CITY OF ALBUQUERQUE

July 7, 2017

Re: Blue Linx, 1820 Bellamah Ave. NW
Request for Certificate of Occupancy- Transportation Development
Architect's Stamp dated 2-1-16 (J13D101)
Certification dated 7-6-17

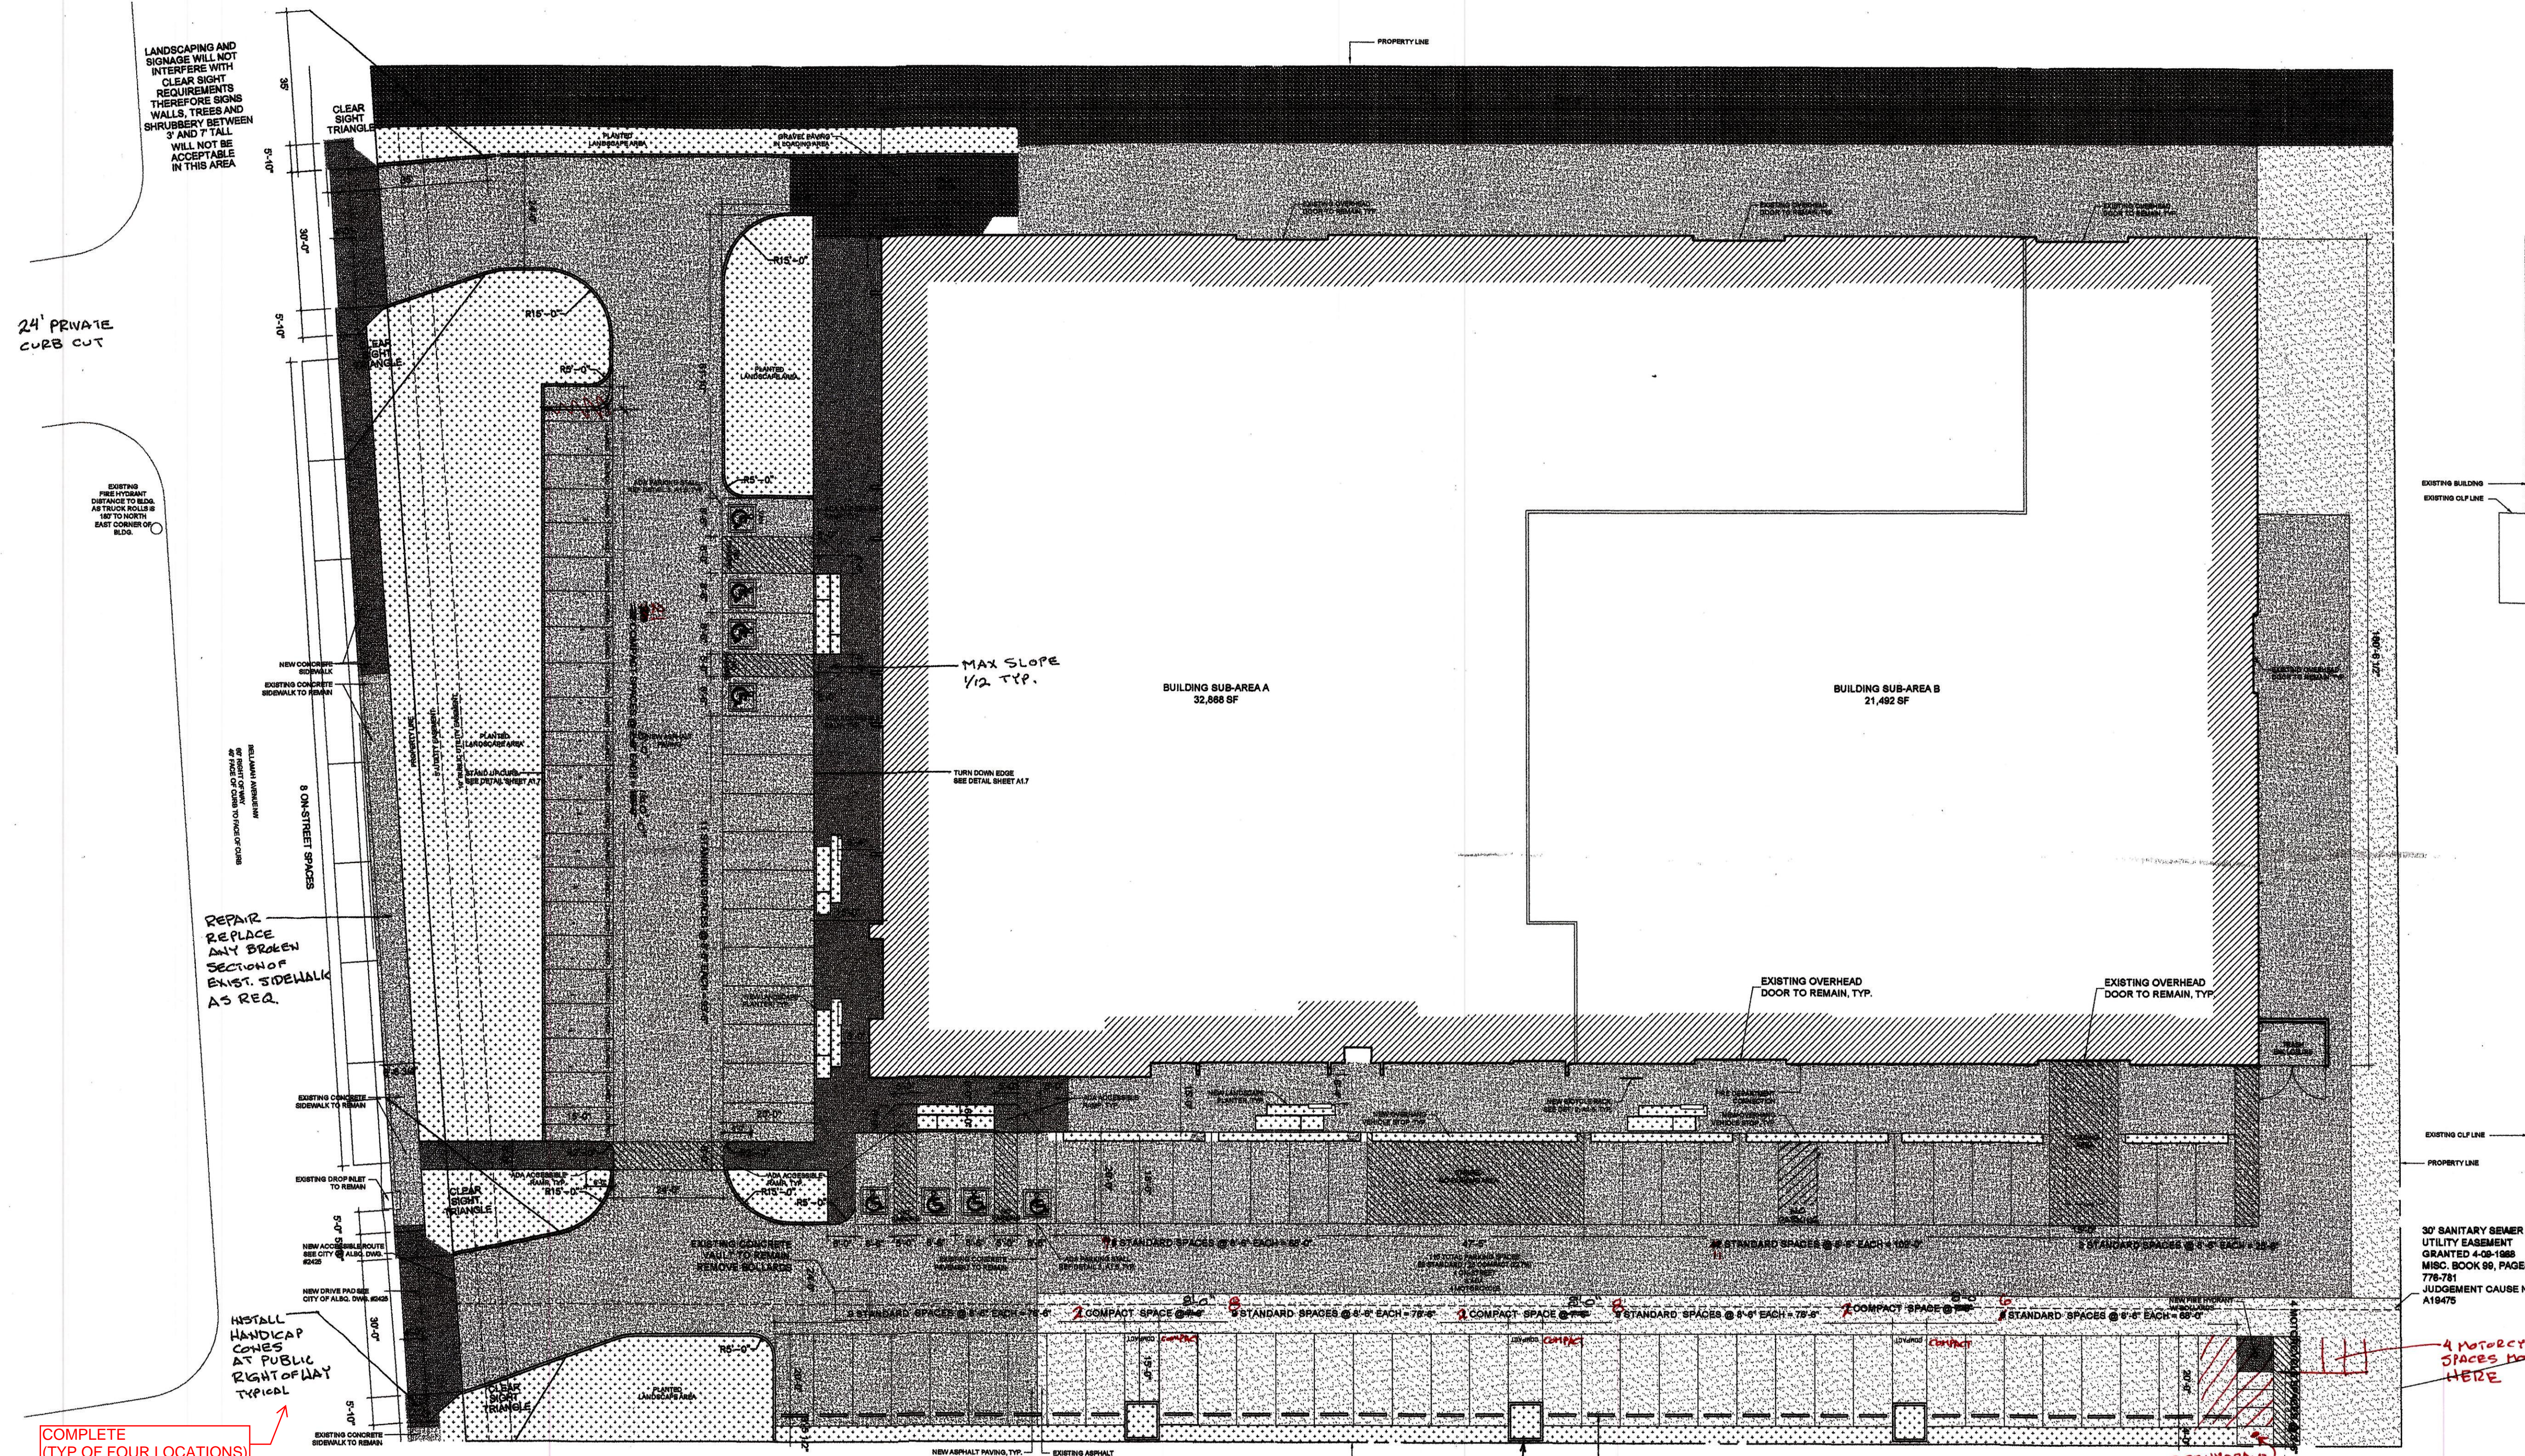
- Provide Truncated Domes for the ADA ramp at public Right Of Way.
- Please red mark the site plan that there are four COMPACT parking spaces, not two on the west side of the site.
